An  
Bord  
Pleanála

**Board Direction**  
**BD-005419-20**  
**ABP-305982-19**

The Board decided to refuse permission for the following reasons and considerations.

TYPICAL FLOOR SHOWING DUAL ASPECT APARTMENTS

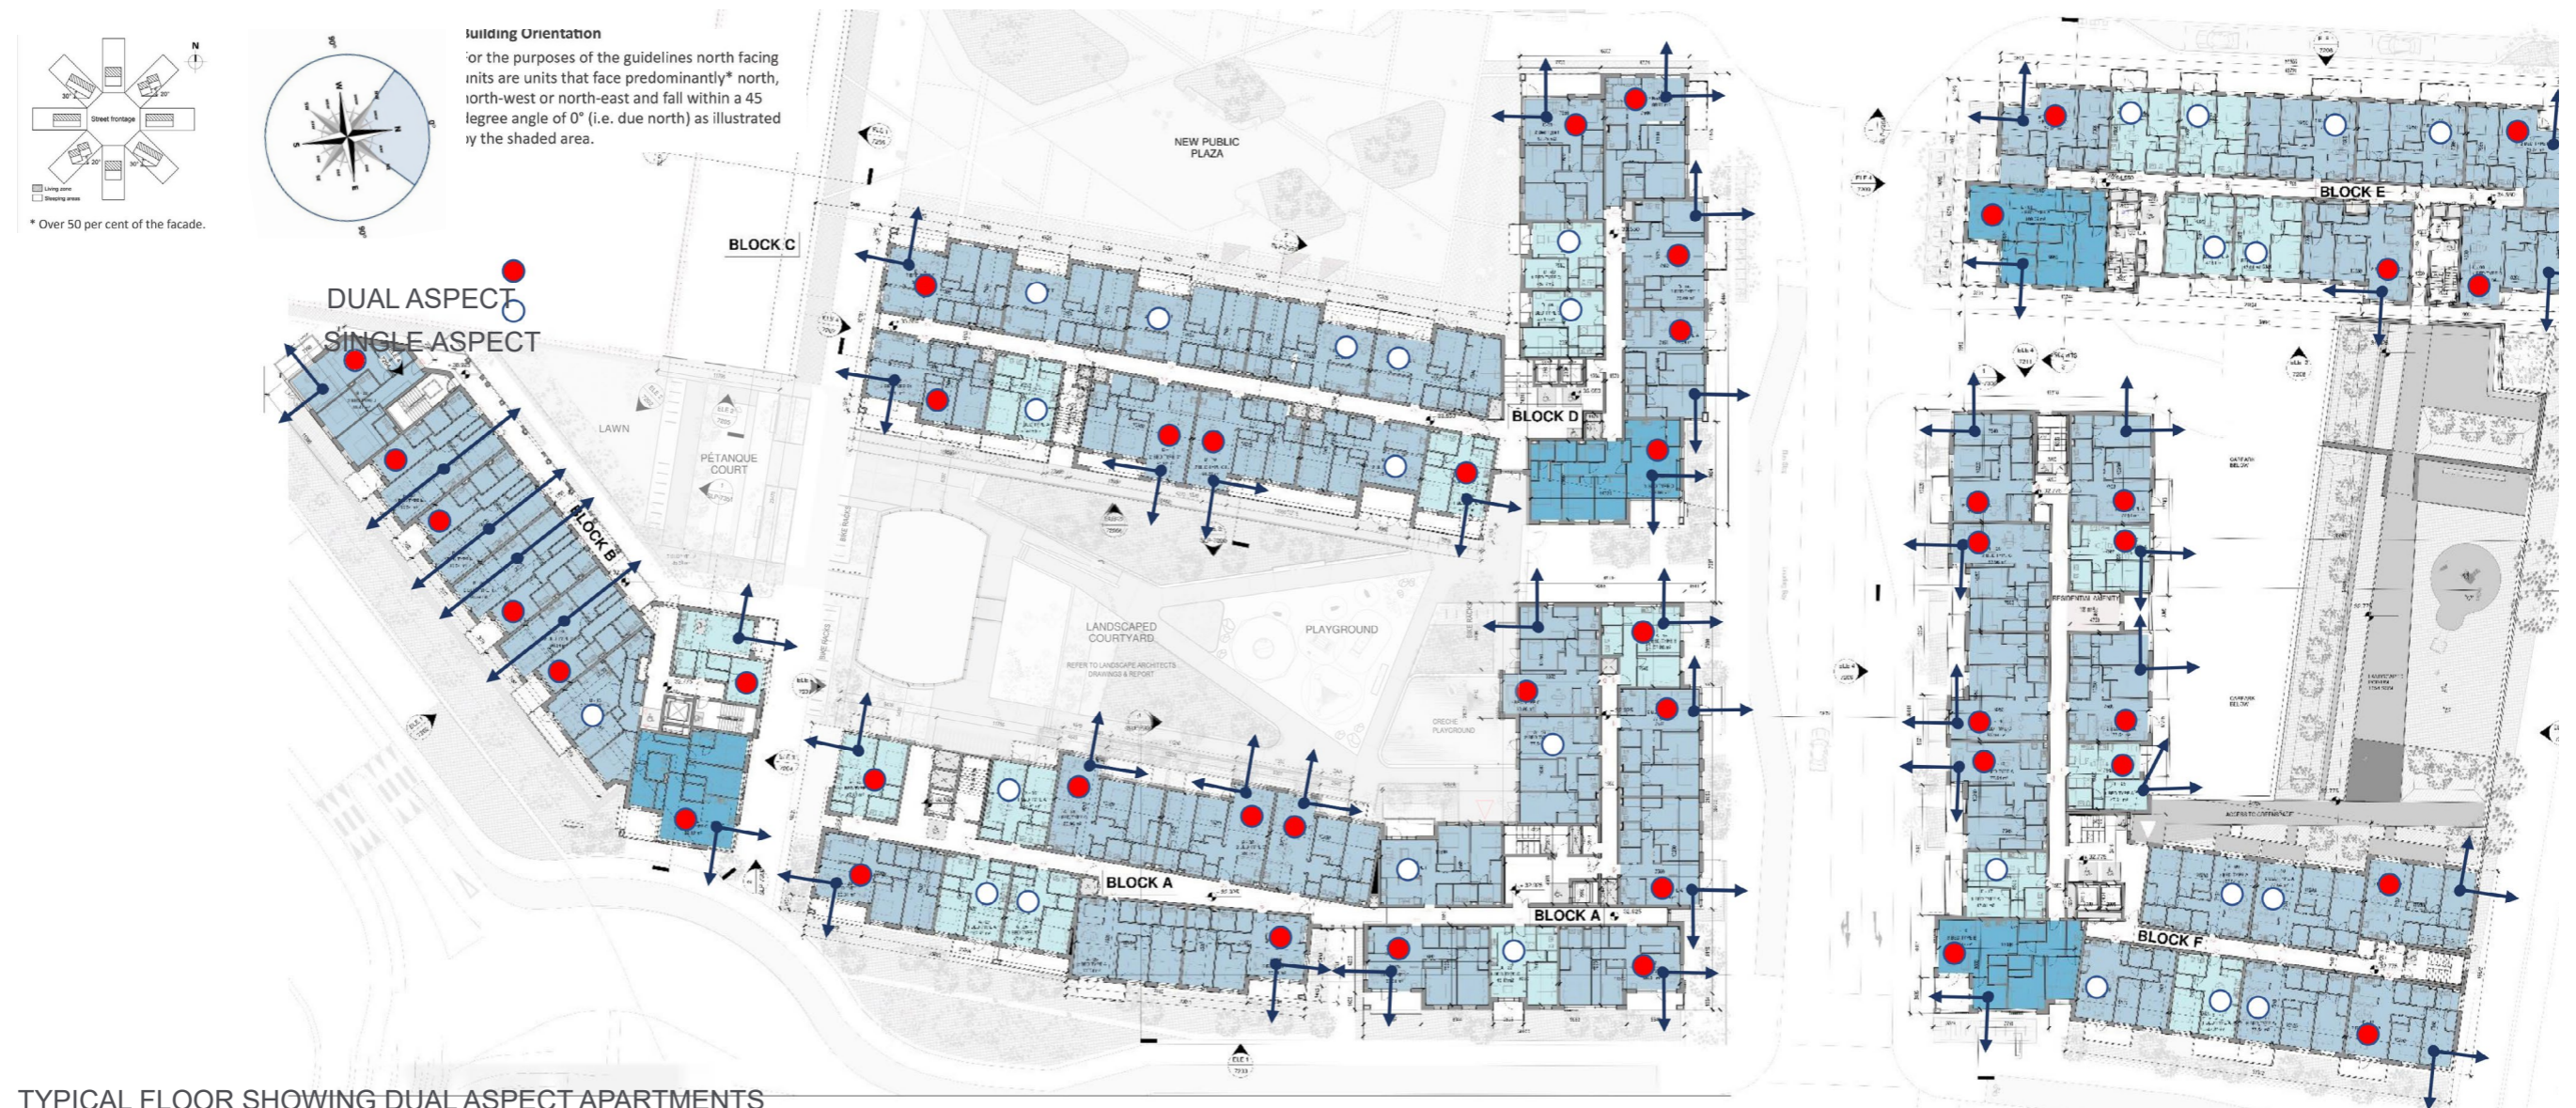
It is a stated objective of Specific Planning Policy Requirement 4 of the Guidelines for Planning Authorities on Sustainable Urban Housing: Design Standards for New Apartments that *“there shall generally be a minimum of 50% dual aspect apartments in a single scheme”*. It is considered that the ratio of dual aspect apartments proposed is substantially below this minimum requirement, and that the proposed development would therefore fail to provide an acceptable standard of amenity for its future occupants. Furthermore, it is considered that the proposed childcare facility provision is deficient in the provision of childcare places and is not in accordance with the guidelines for such facilities. The proposed development would, therefore, be contrary to the proper planning and sustainable development of the area.

In deciding not to accept the Inspector's recommendation to grant permission, the Board considered that, the provision of dual aspect apartments proposed would be unacceptable and would fall significantly below the minimum requirement, and that the changes which would be required to comply with these minimum standards, together with the requirement to increase the number of childcare places provided, would be significant and could not be dealt with by condition.

## 4.10 - Communal Amenity Space

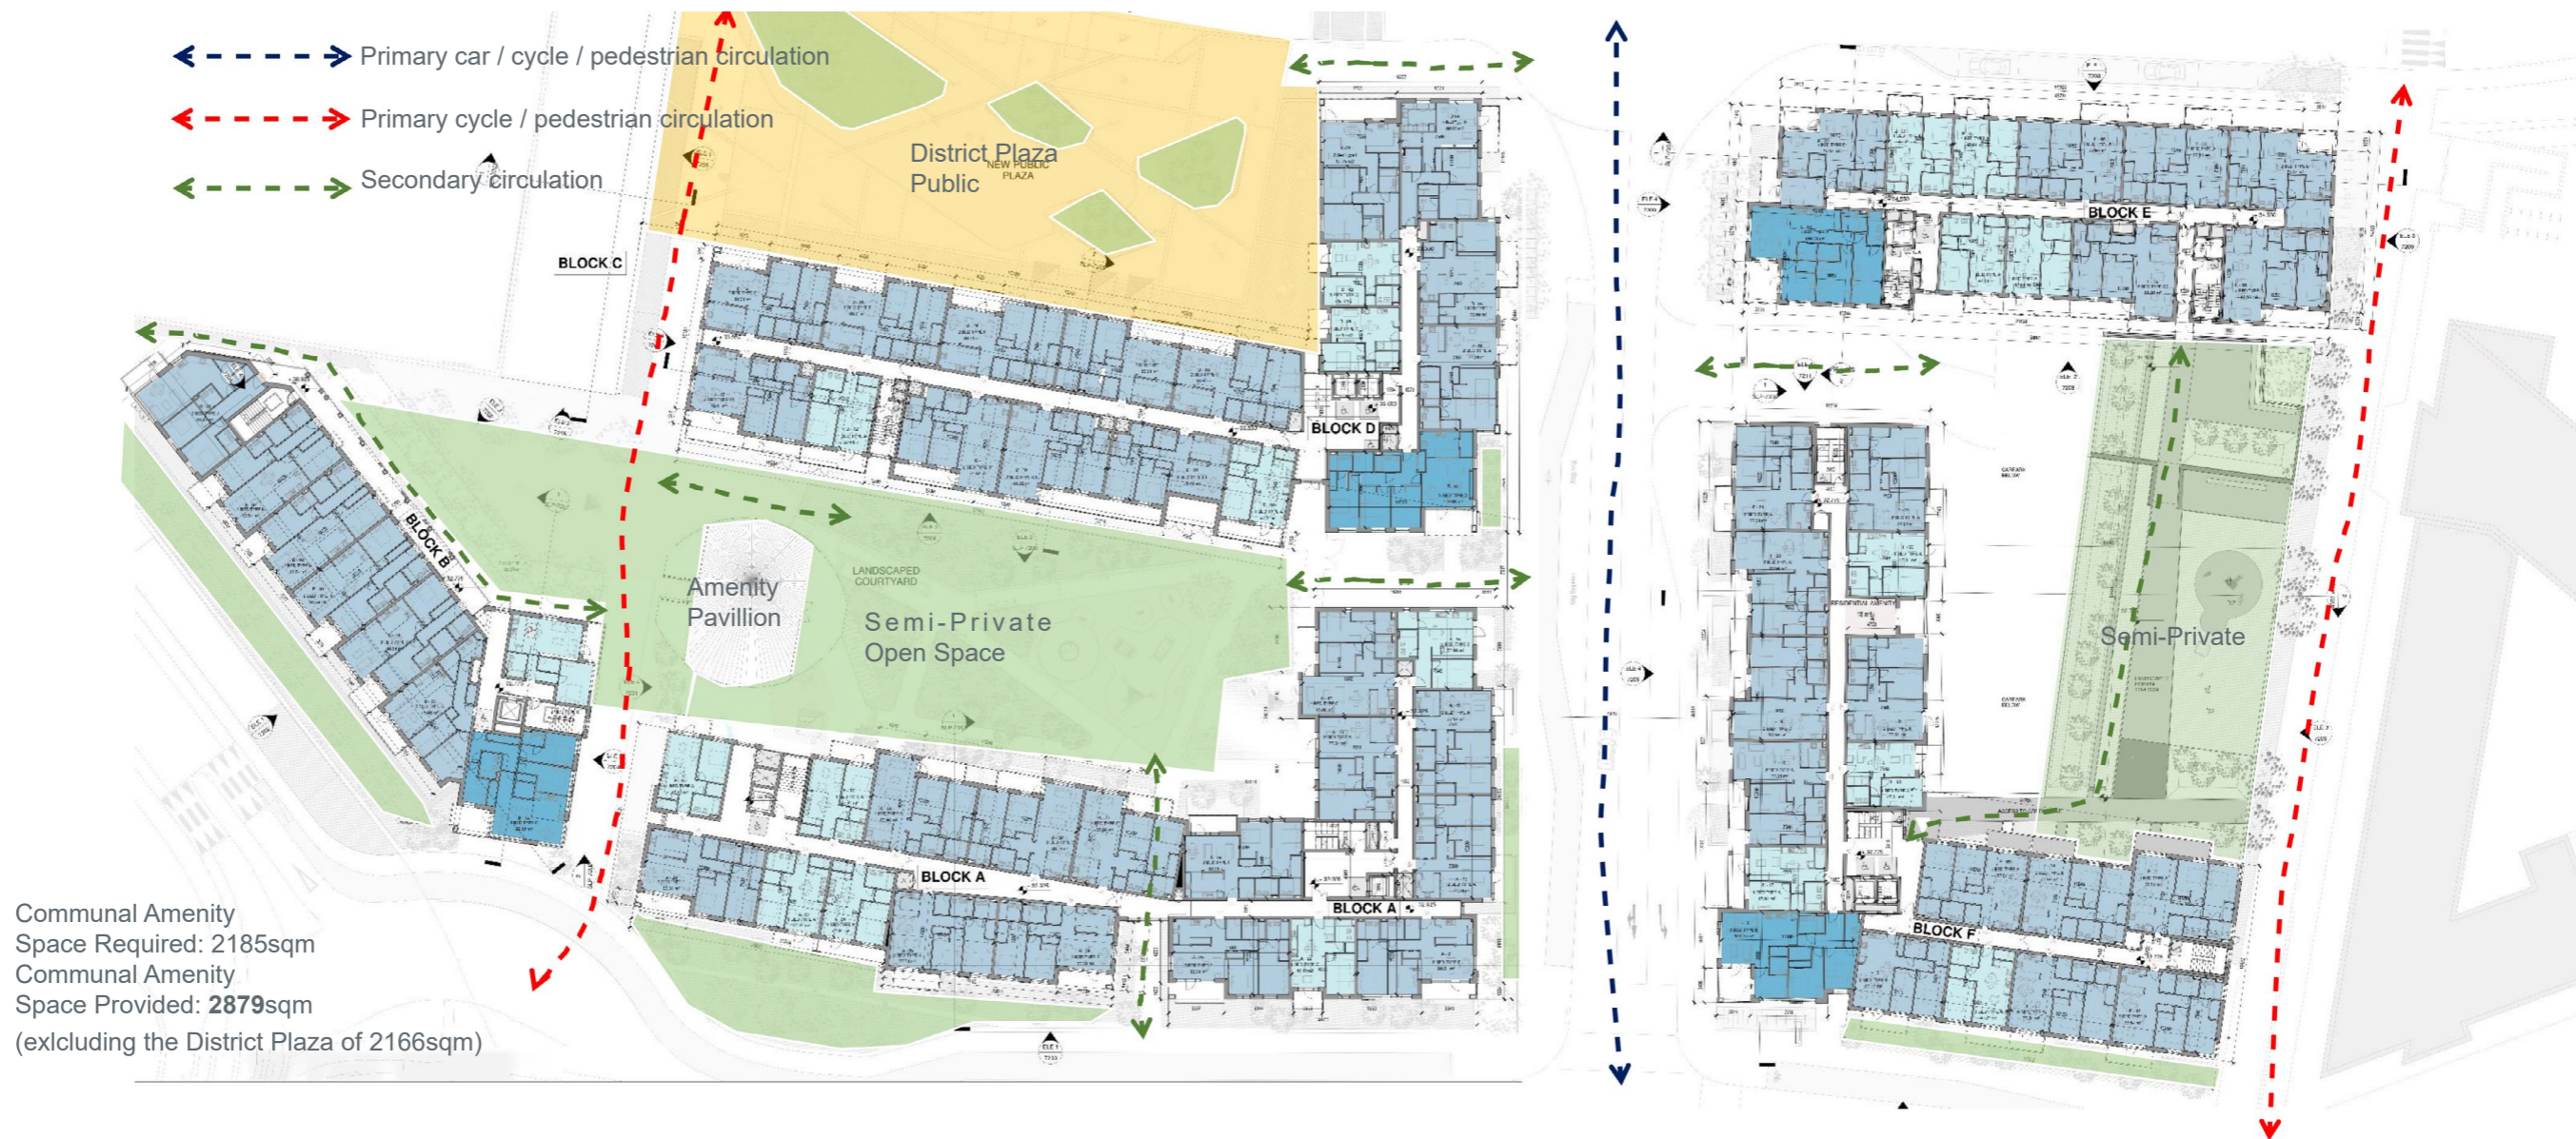
**Note:** The board was not satisfied that the quality of the communal open space, and limited extent of the proposed podium level deck between Blocks E and F, would provide a sufficient visual and residential amenity for future occupants.

Figure 3.3.1: Winter Pedestrian Comfort rating of the balconies, view from south

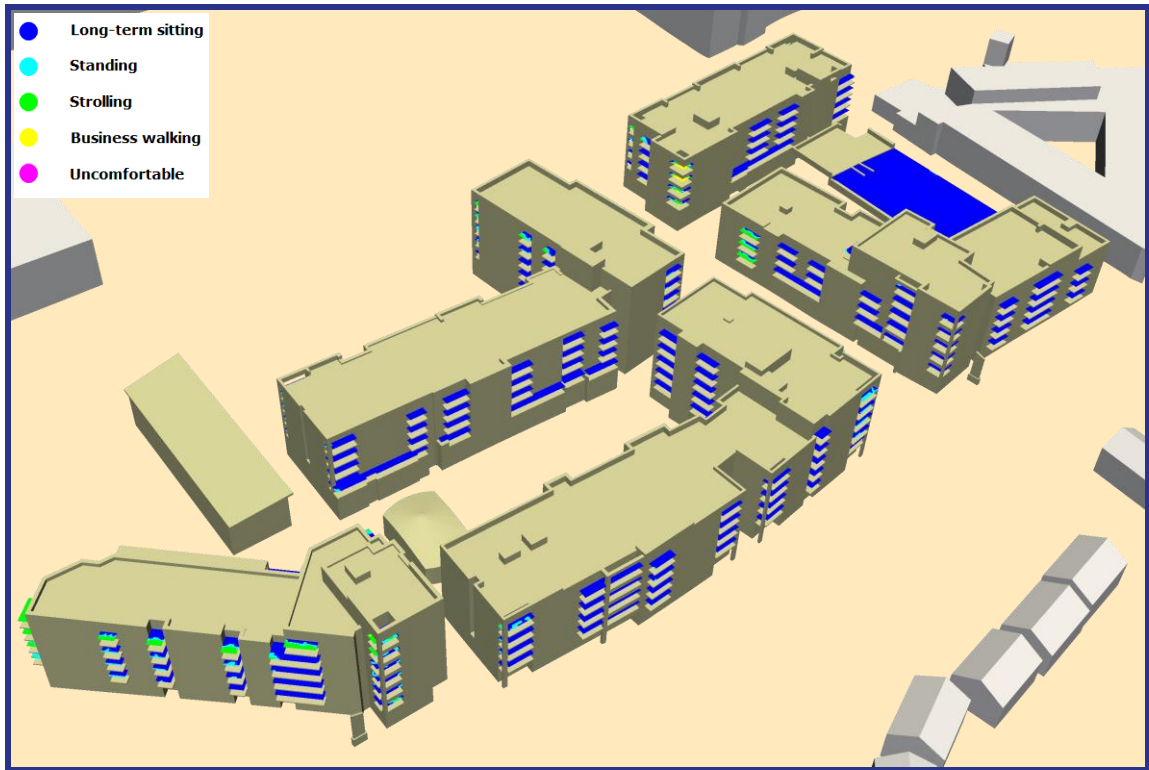
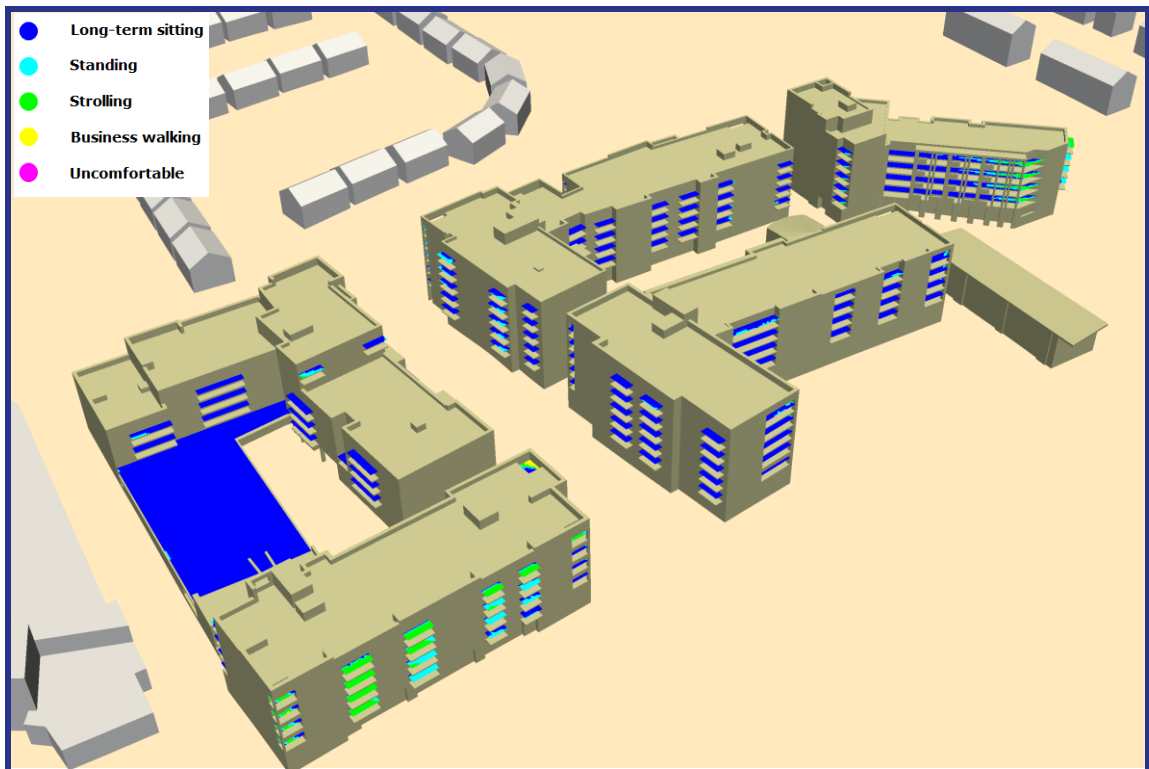
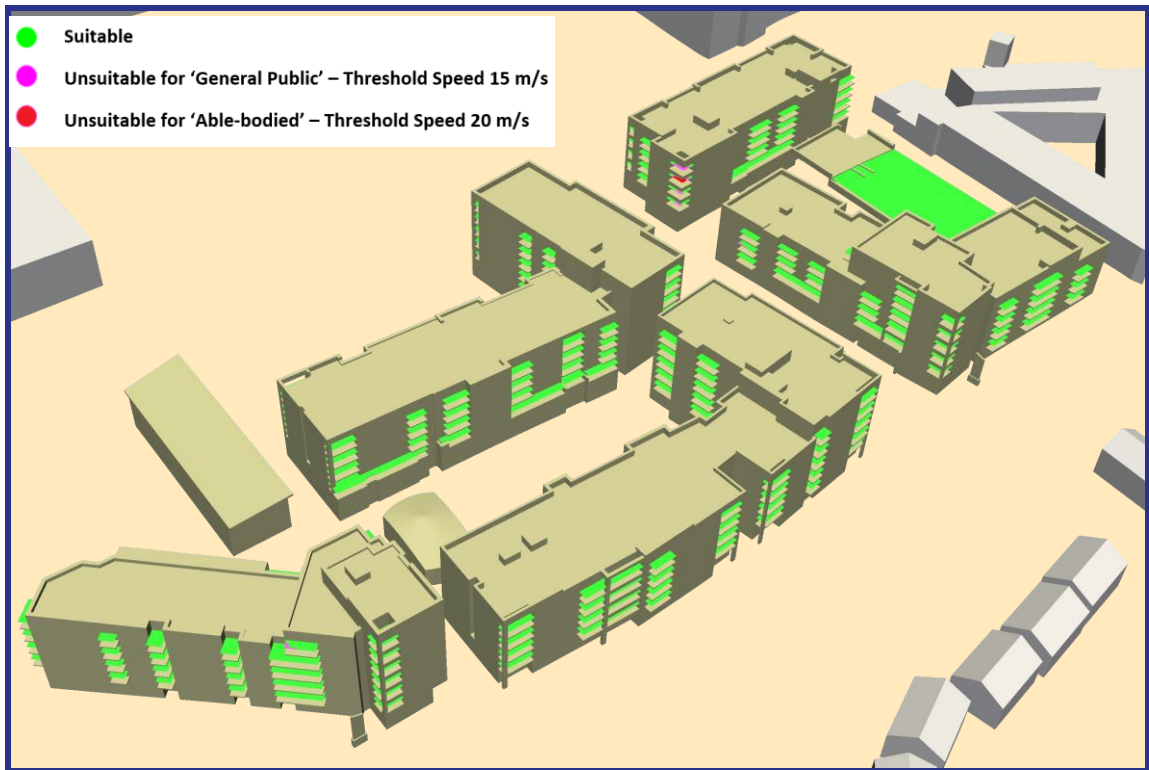
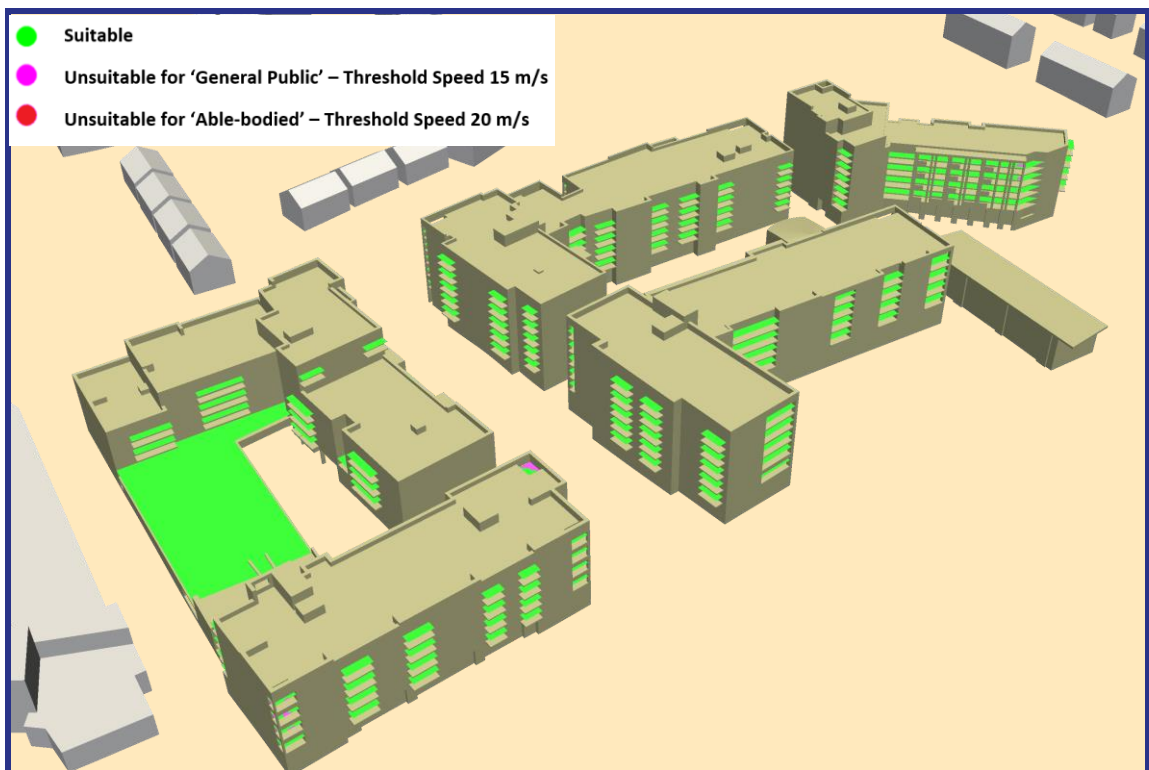
The Board noted the concerns of the planning authority with regard to the exposed nature of the site, and the negative impacts of the prevailing winds in the area on high level balconies, and the results of the Wind Microclimate Assessment provided by the applicant, and considered that the changes required to achieve the level of mitigation required would be significant.
